Rezoning Transportation Analysis

Petition Number: 2019-160

Date	Description
12-18-19	First Review
1-16-2020	Second Review
02-18-2020	Third Review (WB)

Conceptual Site Plan

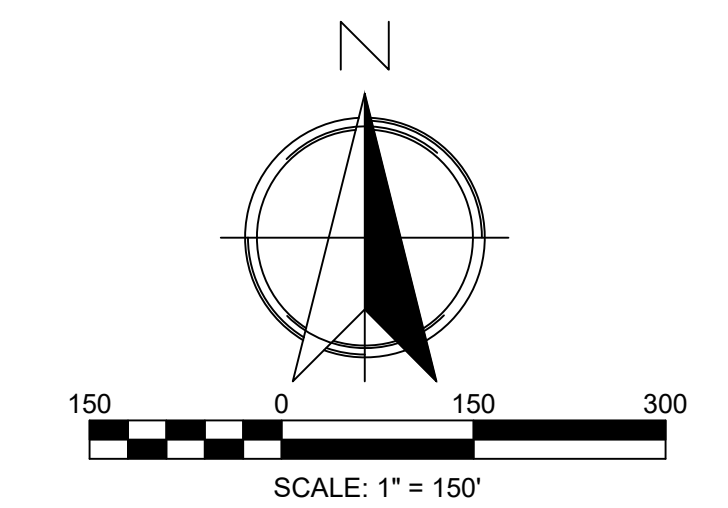
4. The petitioner should revise the site plan and conditional notes to commit to a left turn lane on Kelly Road at proposed Road H with a minimum of 150 feet of storage and 100-foot taper.

5. CDOT requests the petitioner convert proposed townhomes on public streets to be alley fed where feasible in order to minimize vehicle and pedestrian conflicts and provide a safer sidewalk network.

6. The petitioner should revise the site plan to add a note specifying dedication and fee simple conveyance of all rights of way to the City before the site's first building certificate of occupancy is issued. CDOT requests right of way set at 2' behind back of sidewalk where feasible.

7. The petitioner should revise the site plan to add a note specifying all transportation improvements will be approved and constructed before the site's first building certificate of occupancy is issued. The petitioner may phase transportation improvements if said improvements and phasing are explicitly described in site plan notes.
